Our Ref: SDNP/19/01425/ADJAUT
Contact Officer: Sarah Griffiee

Neighbouring Authority Consultation

Proposal: WA/23/19/DOC - Approval of details reserved by condition imposed under ref WA/84/17/PL relating to Condition Nos 4 vehicular access and 6 external lighting.
Address: Fairmead Farm Land , Binsted Lane , Arundel , BN18 0LQ ,

SWEPT PATH ANALYSIS USING A
TRACTOR AND TRAILER

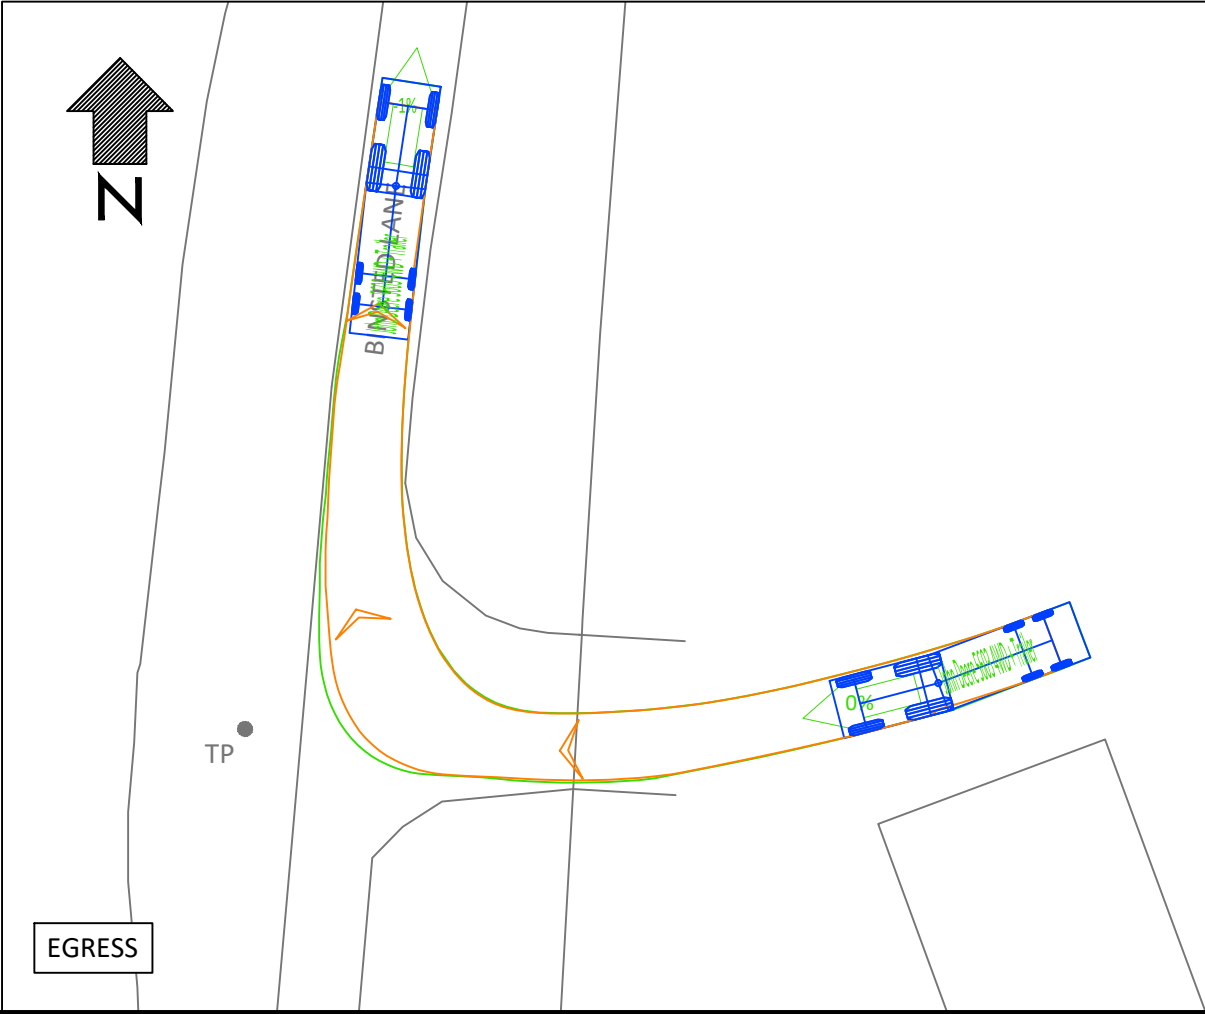
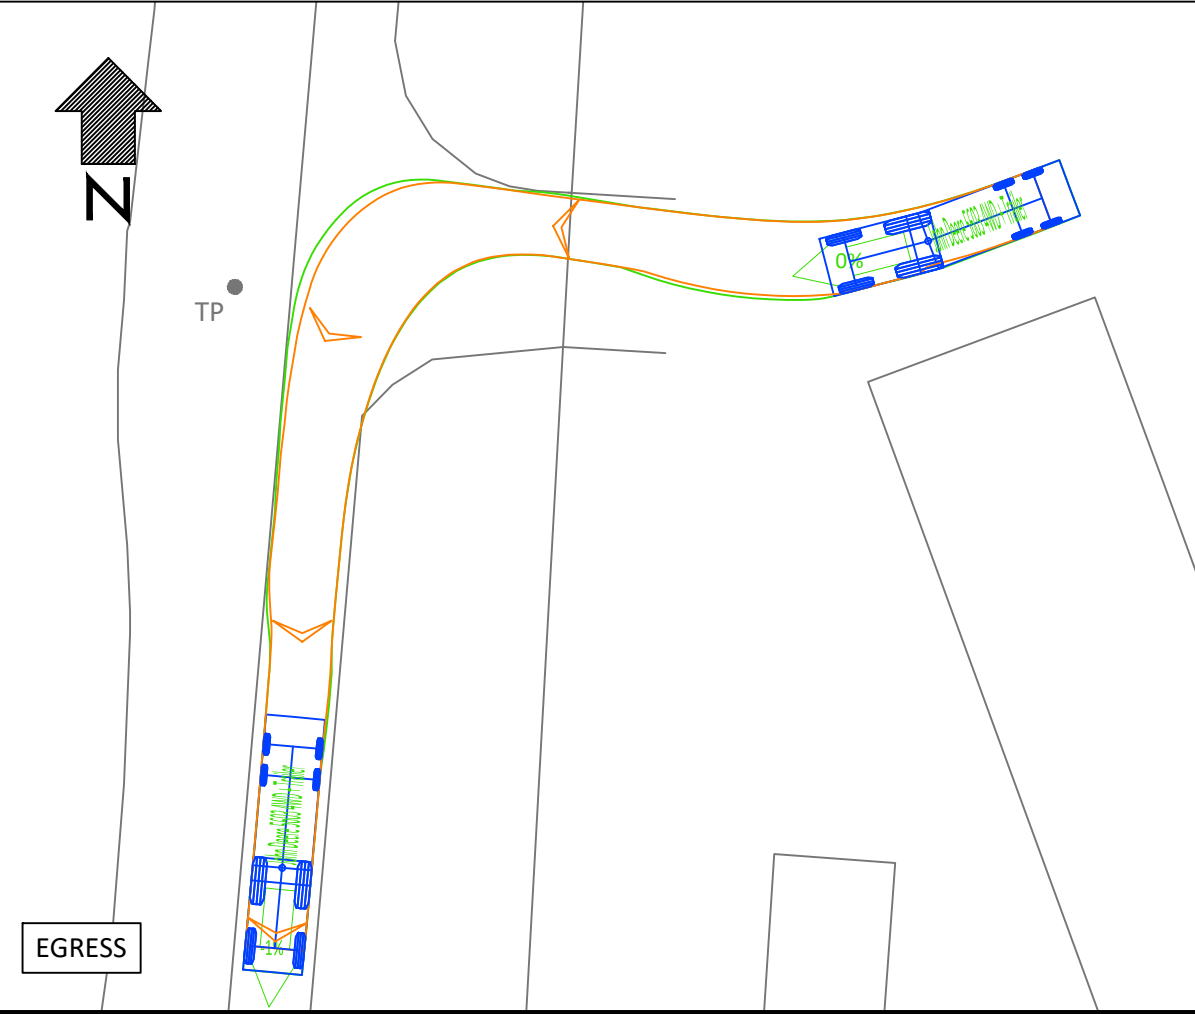
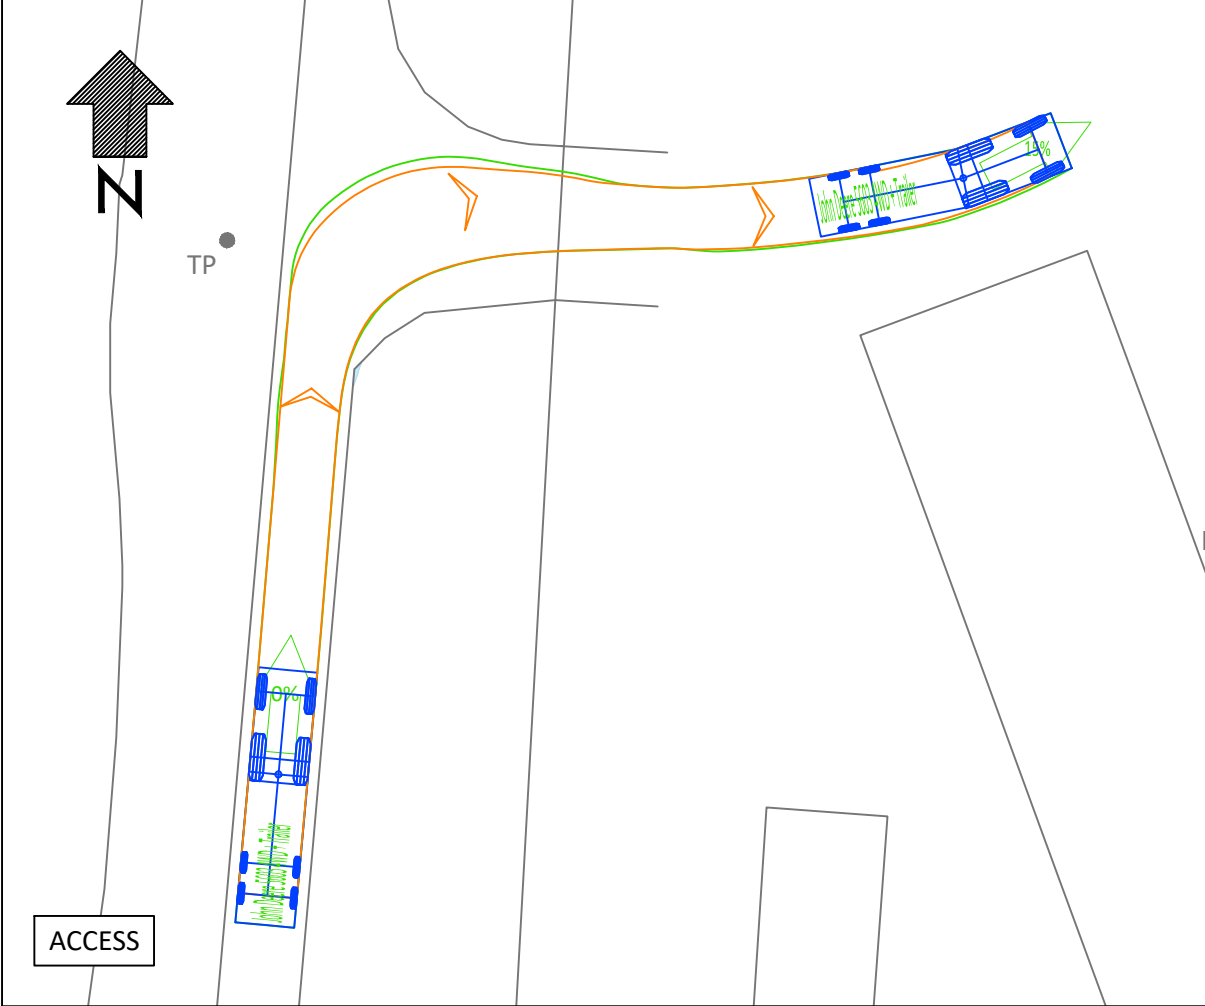
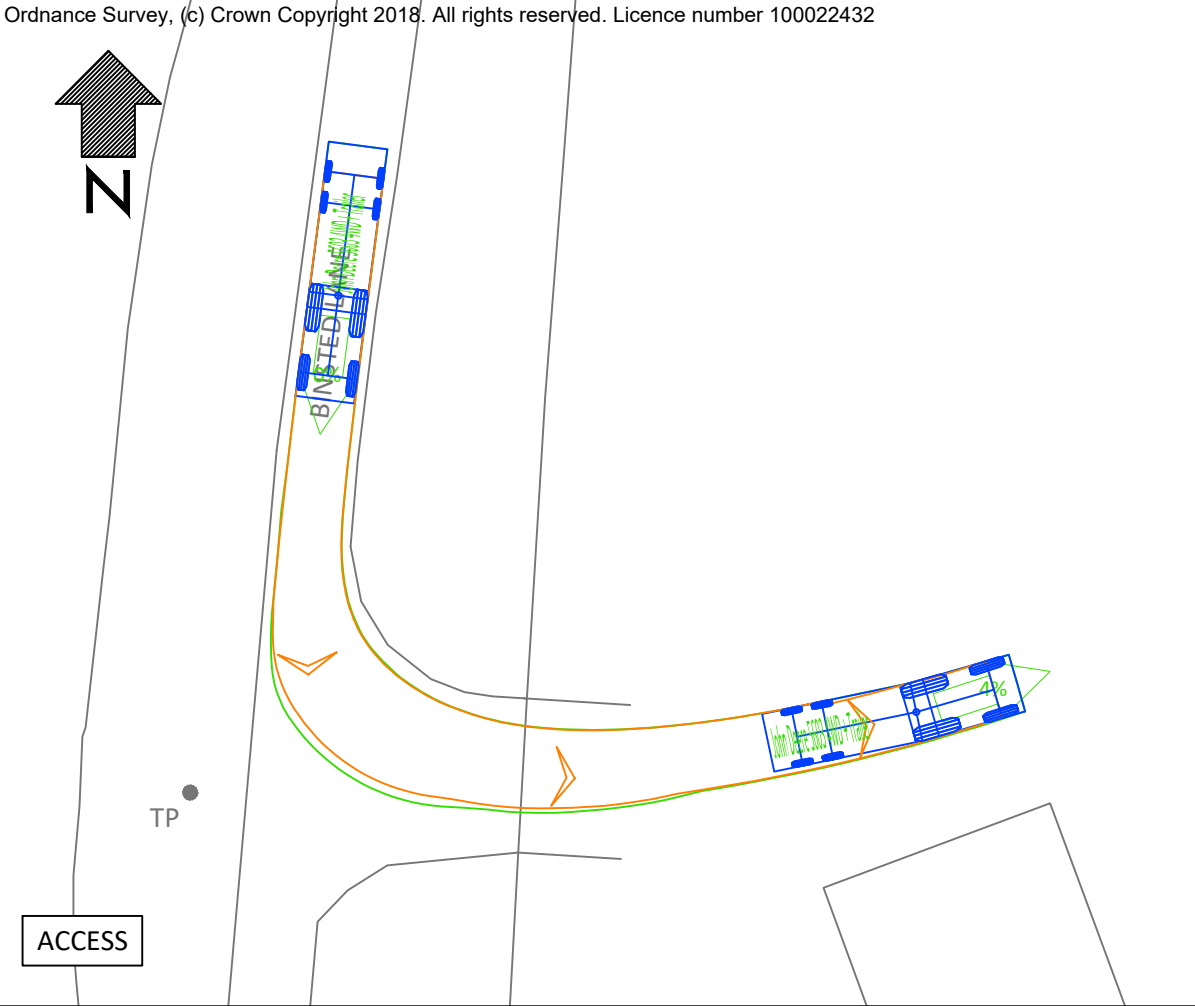
In regards to vehicle access, the swept path analysis shows that the size of the access is limited to that which is necessary for functionality. It is recommended that Highways are consulted on this to provide specialist comments. In regard to the appearance, a low key access is recommended without a formalised kerb to reflect the rural, countryside location and the character of other existing accesses along the road.
